Re: Dish Wireless site – DNDEN00250B
 14 E Clover Cir
 Parcel 6505104061

Dish is seeking approval for a proposed co-location onto an existing 140'-0" Stratmoor Hills Water Tower. All antennas and associated equipment will be mounted at 90'.

SHEET NUMBER
A-1

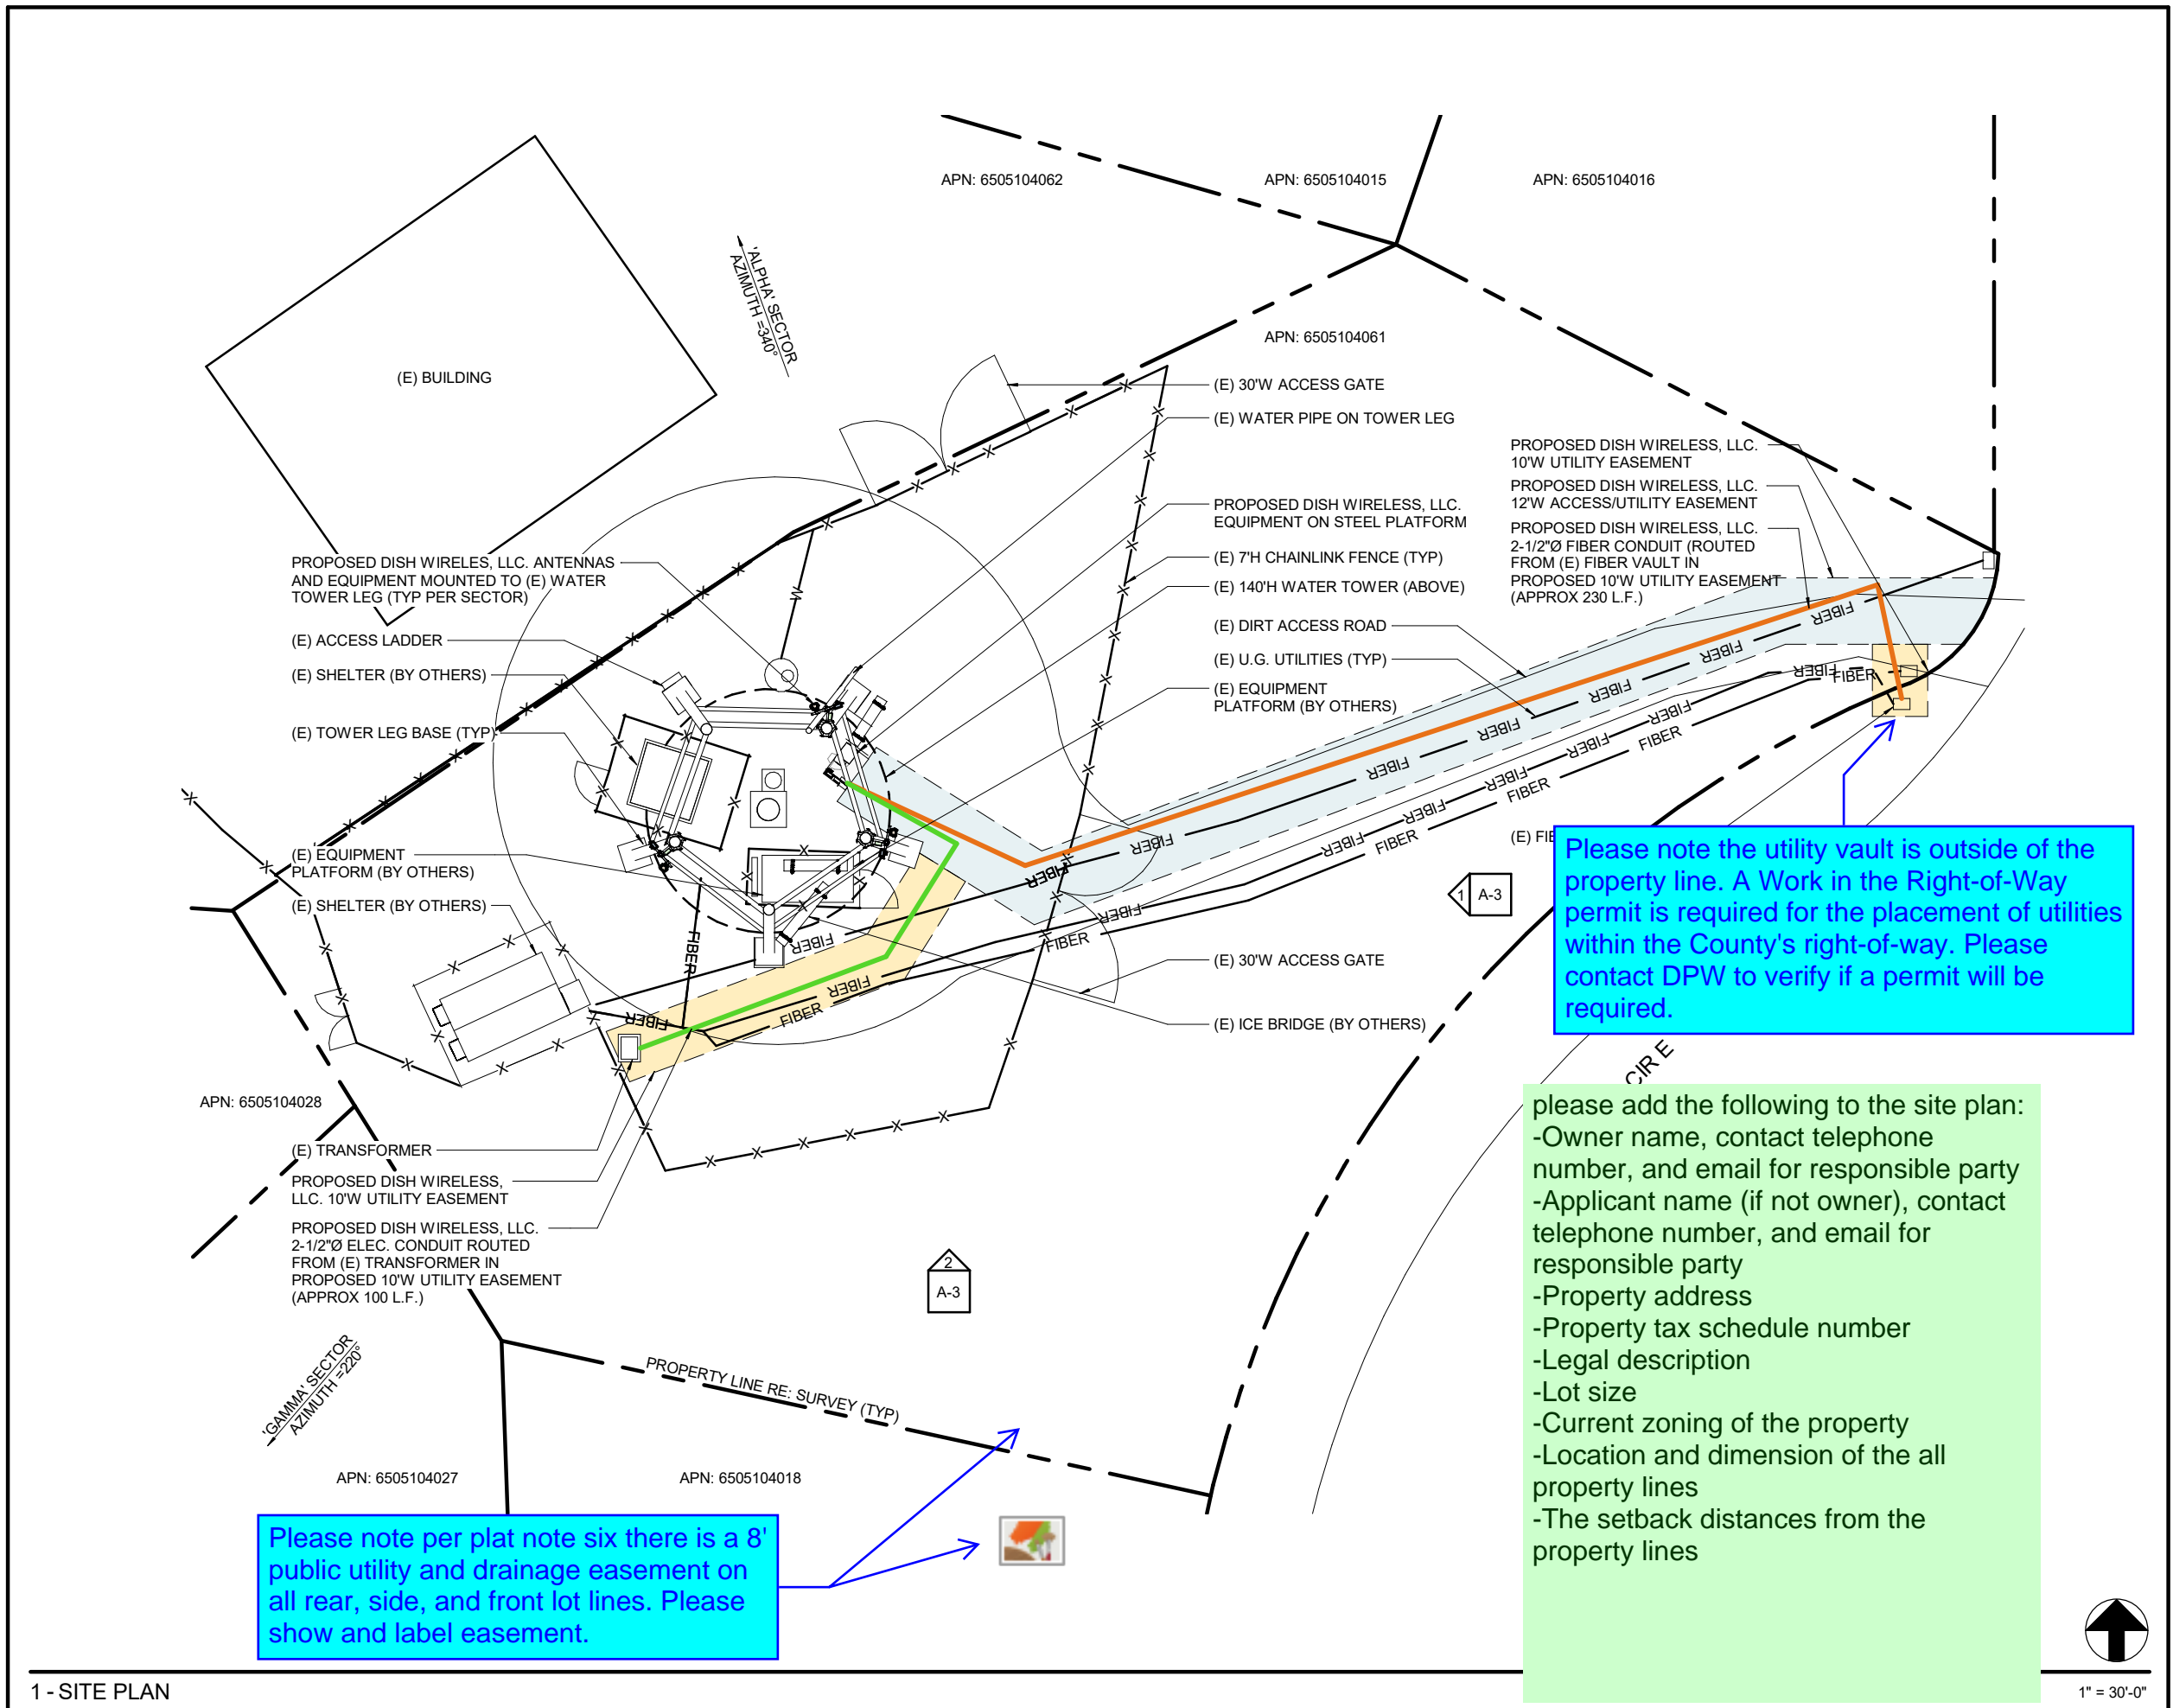
Per proposed work shown on the Site Plan applicant shall contact EPC Department of Public Works to verify requirements on applying for a Work in Right-of-Way permit.
